**Consultation Response from KC,
Highways Development Management****2025/90019 Rose Of York, 466, Bradford Road, Batley, WF17 5LW****Internal alterations to convert public house to one dwelling****Date Responded: 03/04/2025****Responding Officer: D. Stainsby****Responding Ref: K13-10SE/32**

This application is for Internal alterations to convert public house to one dwelling at Rose of York, 466 Bradford Road, Batley.

BLOCK/SITE PLAN
AREA 90m x 90m
SCALE 1:500 on A4
CENTRE COORDINATES: 424491, 424386

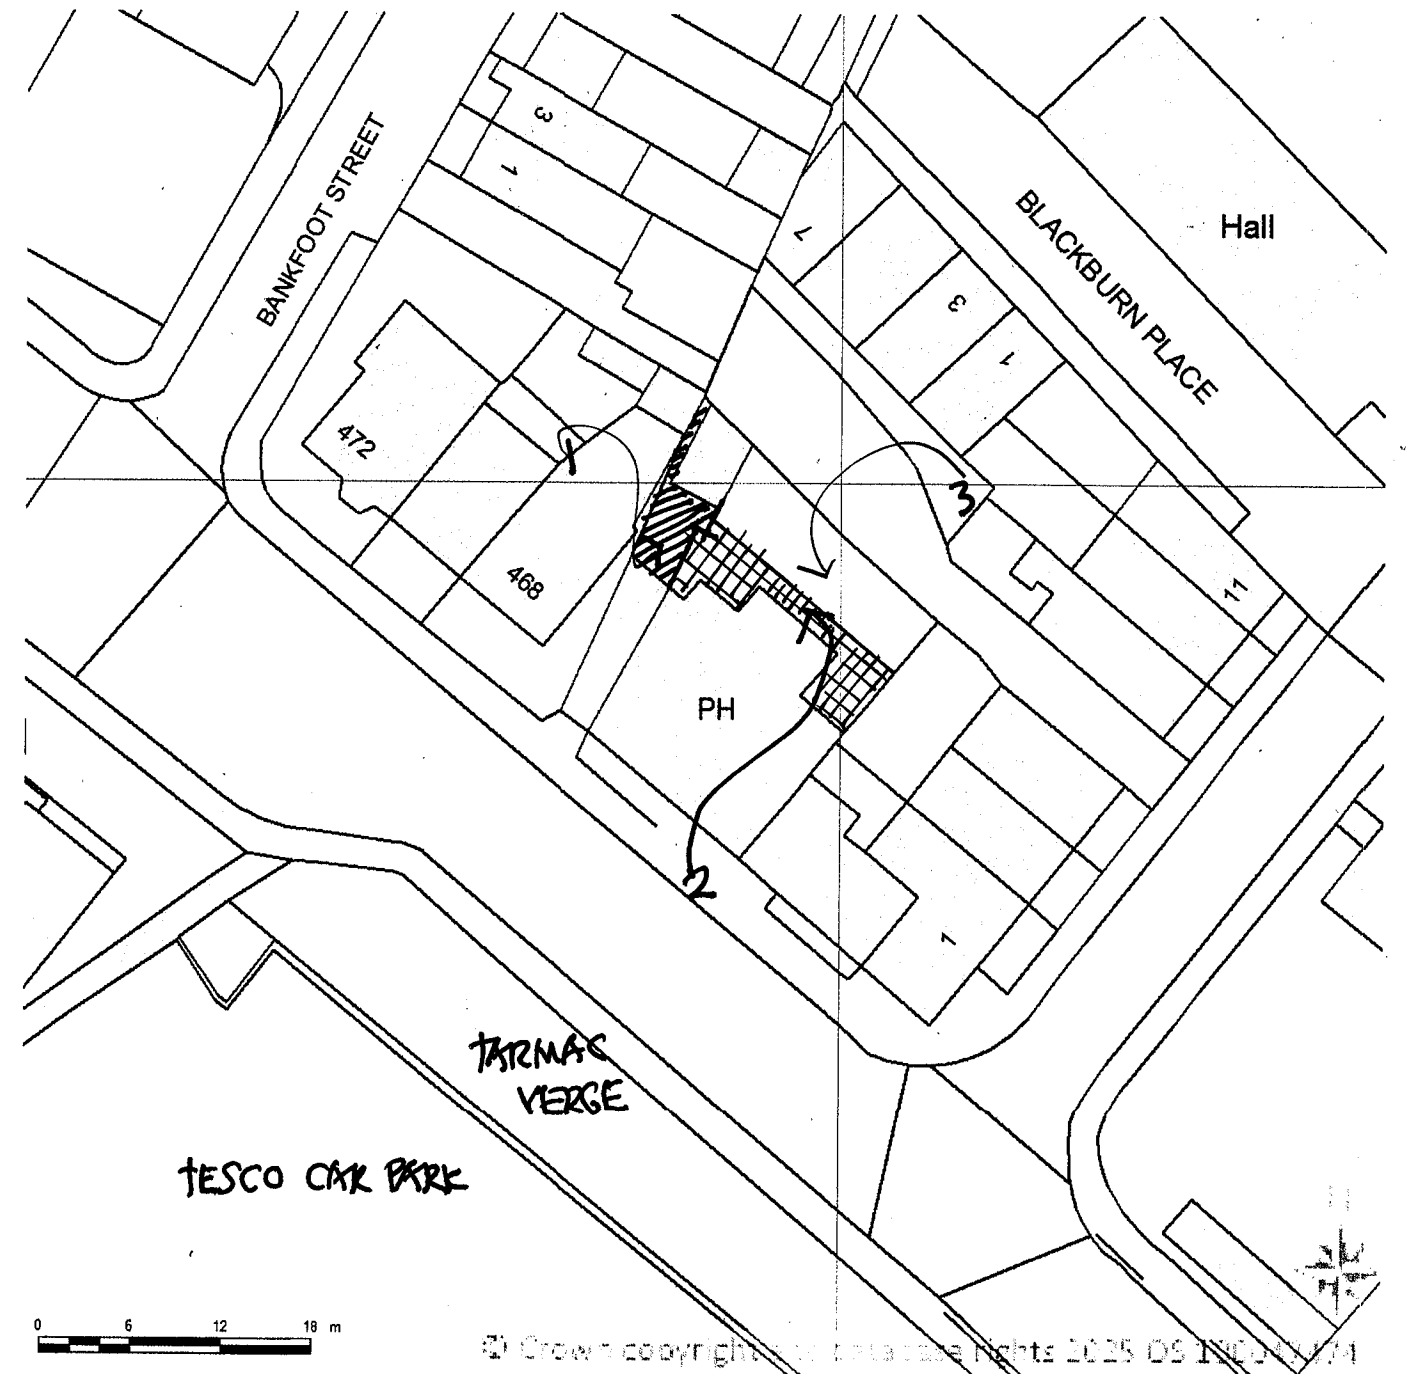
Vehicle access to the site from Bradford Road will remain as existing and is unaffected by the proposals.

Parking is proposed for 3 vehicles and space is available for internal turning which is acceptable

The approved vehicle parking areas will need to be surfaced and drained in accordance with the Communities and Local Government; and Environment Agencies 'Guidance on the permeable surfacing of front gardens (parking areas)' published 13th May 2009 (ISBN 9781409804864) as amended or superseded.
